Lead Local Flood Authority

Date 25 June 2025

RE: F/14/24/RES – Land at Ford Airfield, Ford, West Sussex

This Reserved Matters application (layout, scale, appearance, landscaping) follows outline consent F/4/20/OUT and covers site-wide drainage.

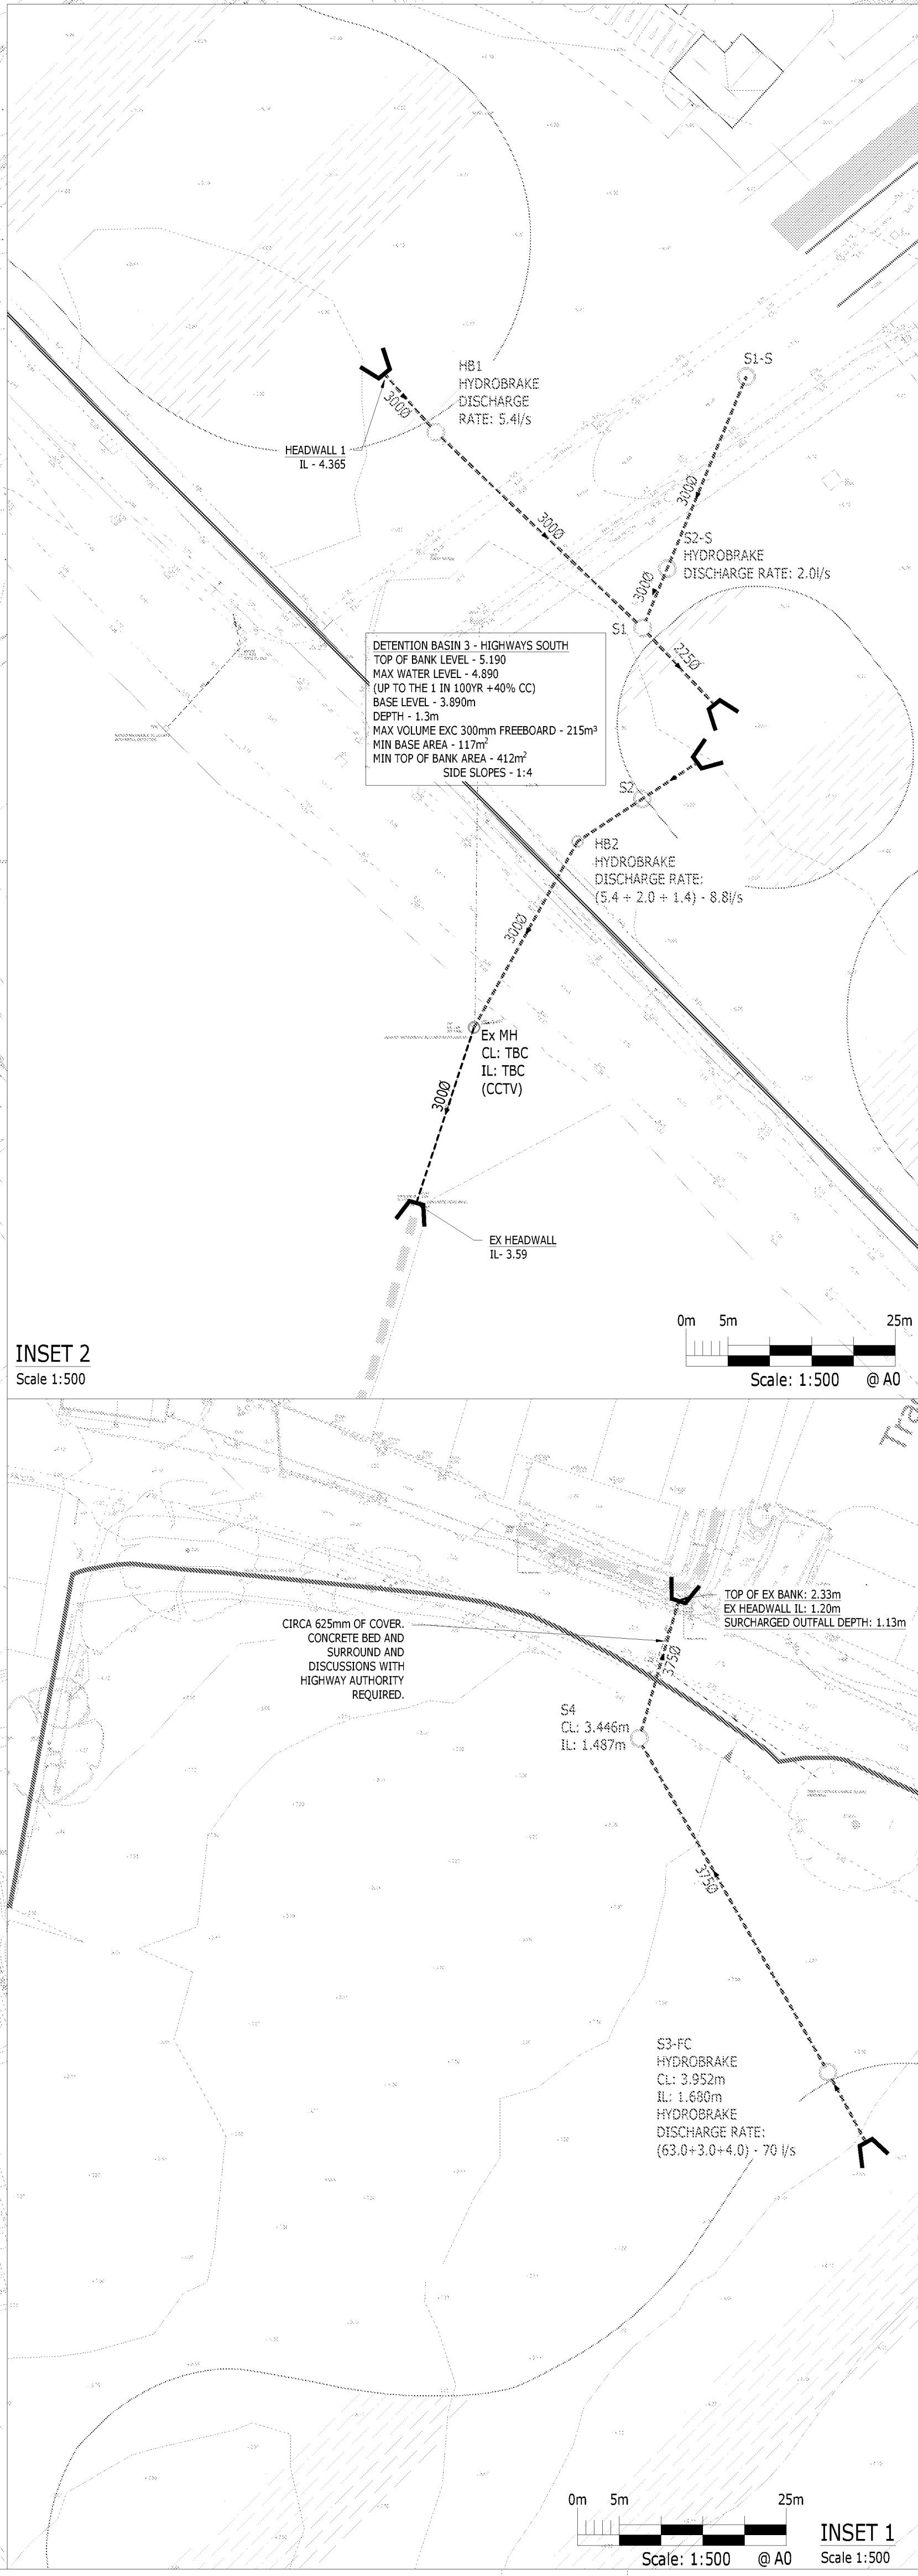
Despite these improvements, a concern remains unresolved. The strategy to discharge all surface water to a single point in the north still lacks sufficient justification. A discharge to a watercourse will only be deemed acceptable where infiltration has been proven to be unviable. No further groundwater investigations have been carried out to support this approach. There existing infiltration testing was also conducted at a depth of 3m, which is below the groundwater table, and is therefore not suitable for assessing shallow infiltration features. We require further investigation into the viability of infiltration, at the location and depth (at least 1m above groundwater levels) of potential soakage features. Their viability could significantly influence the surface water strategy, site layout and flood risk impact.

There are existing depressions on the site that would appear to retain surface water, which would then infiltrate to ground. The applicant will need to ensure that the final discharge of surface water matches the existing situation as closely as practical, in practice this means utilising infiltration (reducing off – site discharge) wherever practical.
